WEST SUSSEX COUNTY COUNCIL CONSULTATION

TO:	Arun District Council FAO: A Wood
FROM:	WSCC - Highways Authority
DATE:	15 October 2019
LOCATION:	General Henry's 31 Horsham Road Littlehampton BN17 6BZ
SUBJECT:	LU/302/19/DOC Approval of details reserved by condition imposed under ref LU/280/17/PL relating to Condition No 4 - parking spaces.
RECOMMENDATION:	Advice

Proposed Conversion Site Plan

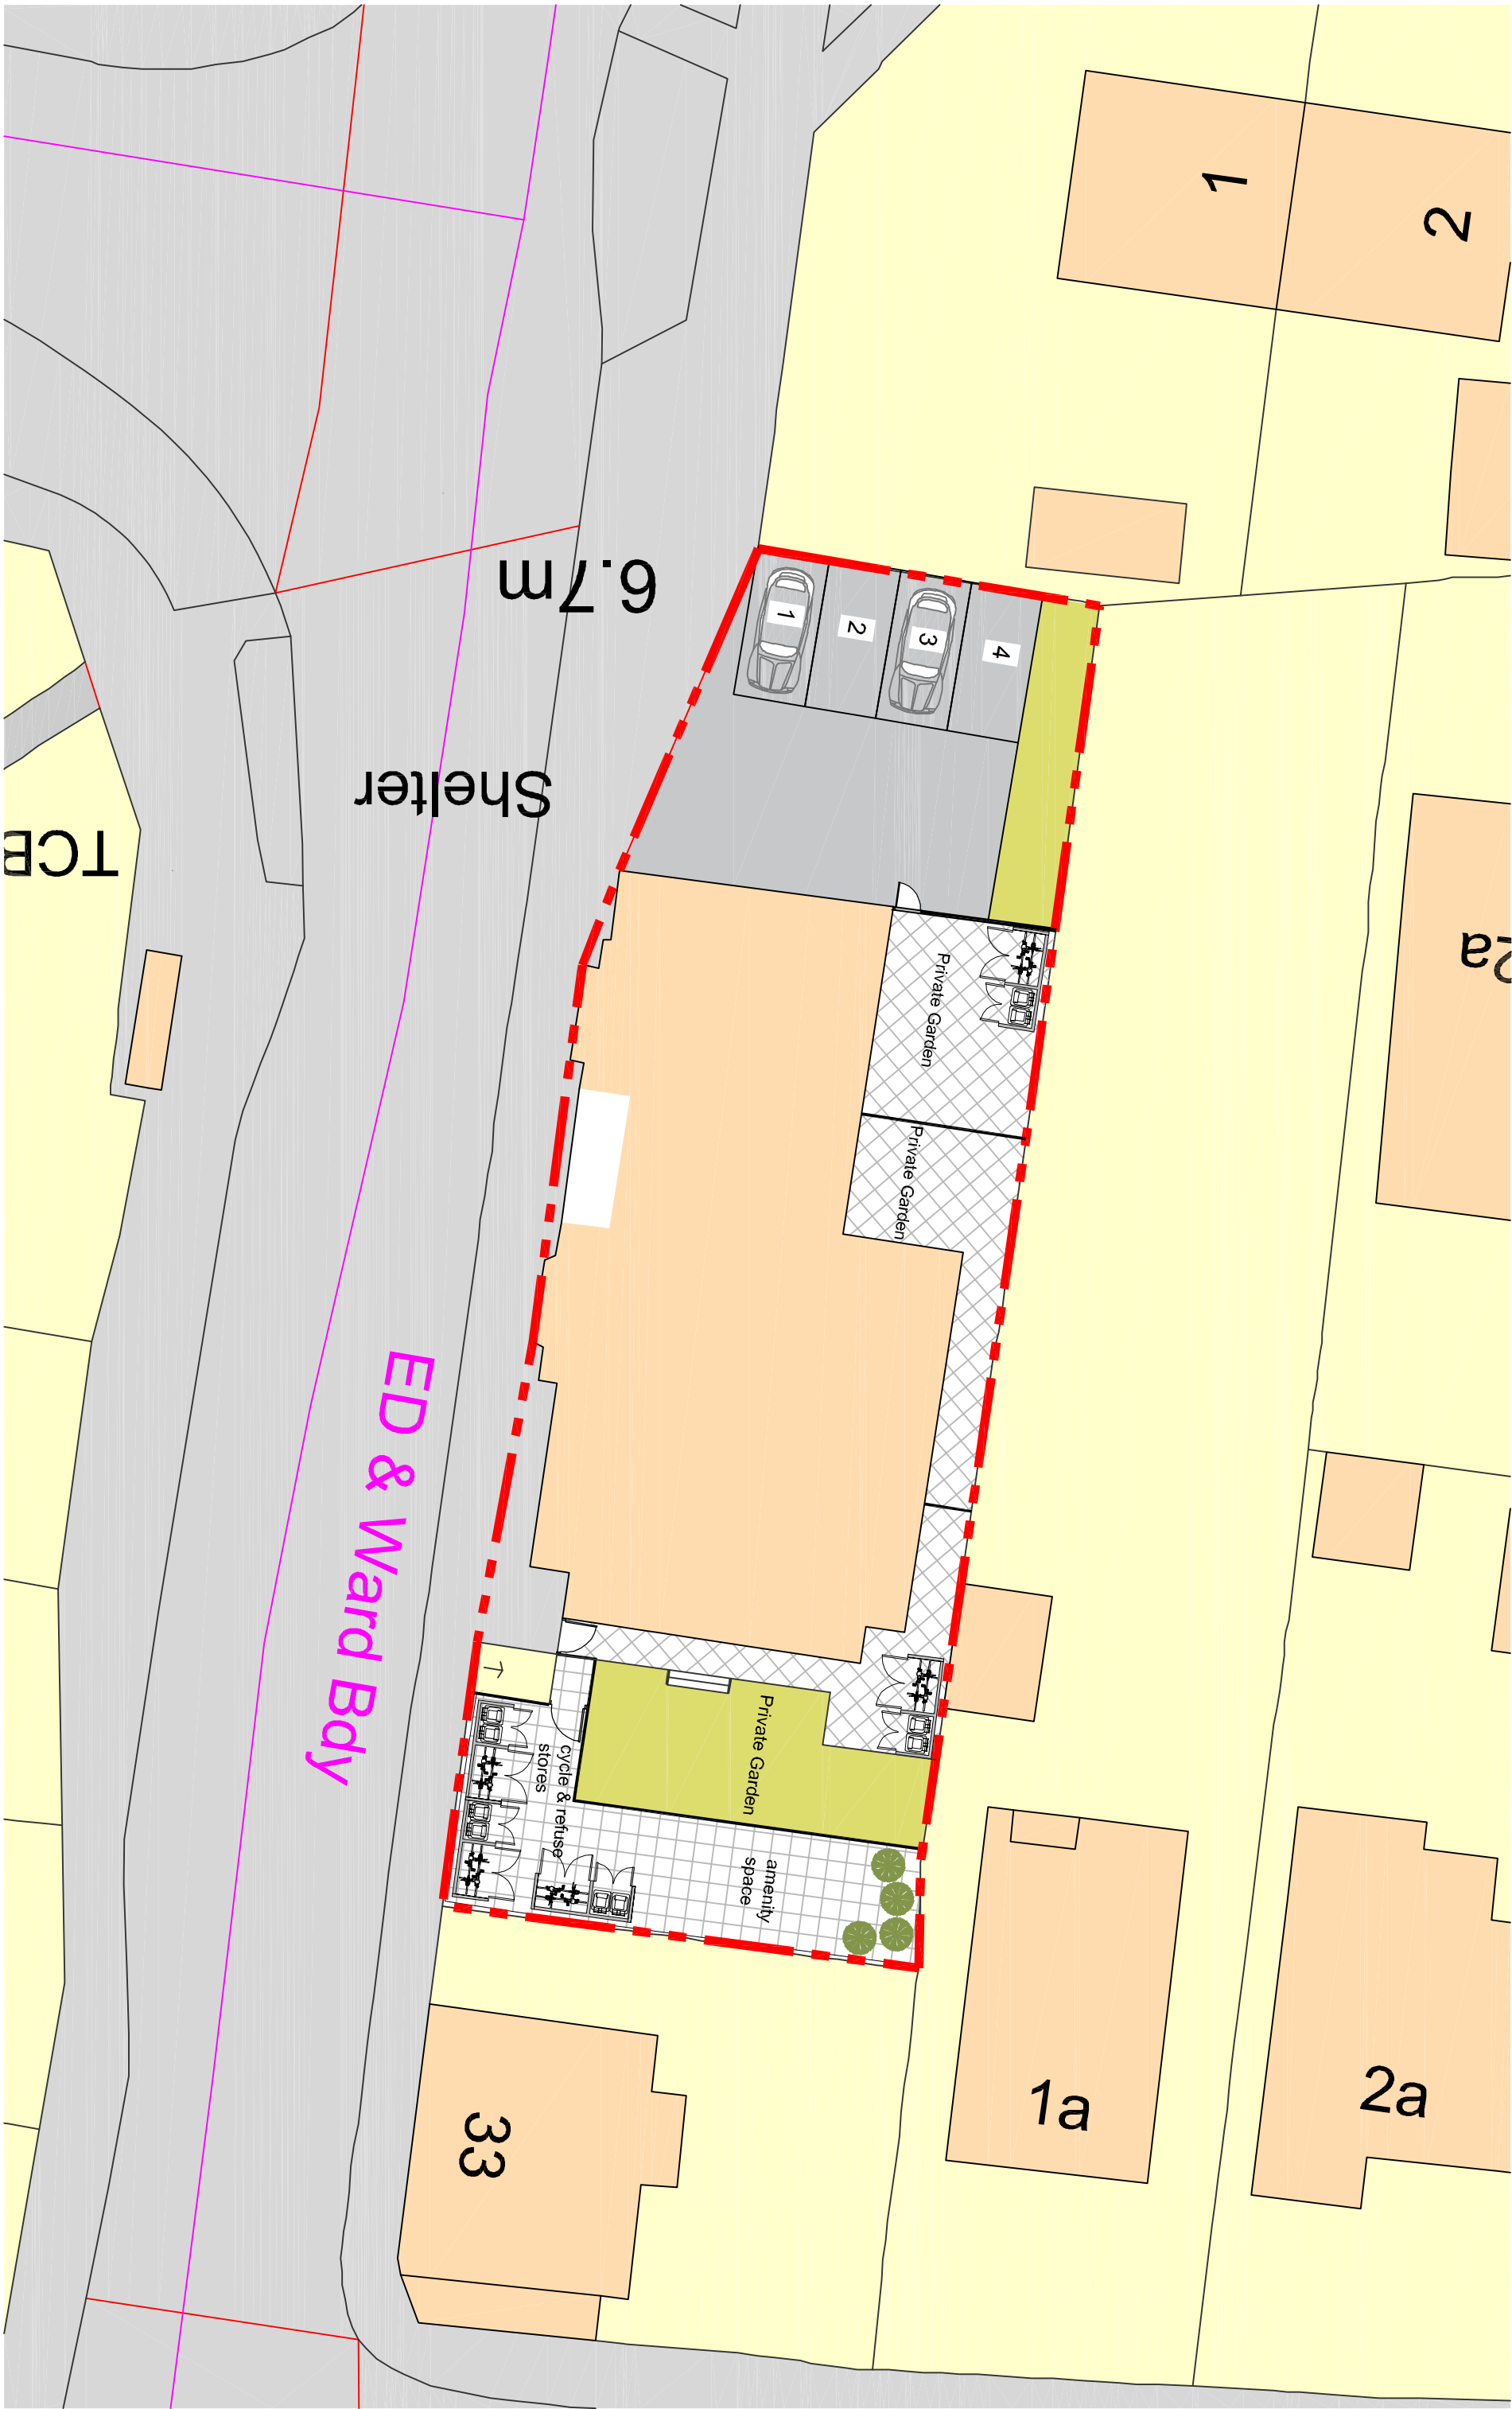
West Sussex County Council, in its capacity as the Local Highway Authority (LHA), have been consulted on discharge of condition 4 attached to approval LU/280/17 (conversion of building to 5 x dwellings). In LHA comments to original application, further information was requested in respect to the parking arrangements, whereby parking was advised to be shown as an unallocated arrangement with all spaces meeting required dimensions of 2.4m by 4.8m.

The fifth parking space has been removed and four spaces shown meet required dimensions without overhanging footway. It is not clear whether these will be of an unallocated arrangement. Nevertheless, the LHA consider that the location provides opportunity for modes of transport other than the private car and does not anticipate a highway safety issue as a result of any overspill parking nearby on street.

The plans and details pertaining to condition 4 are acceptable.
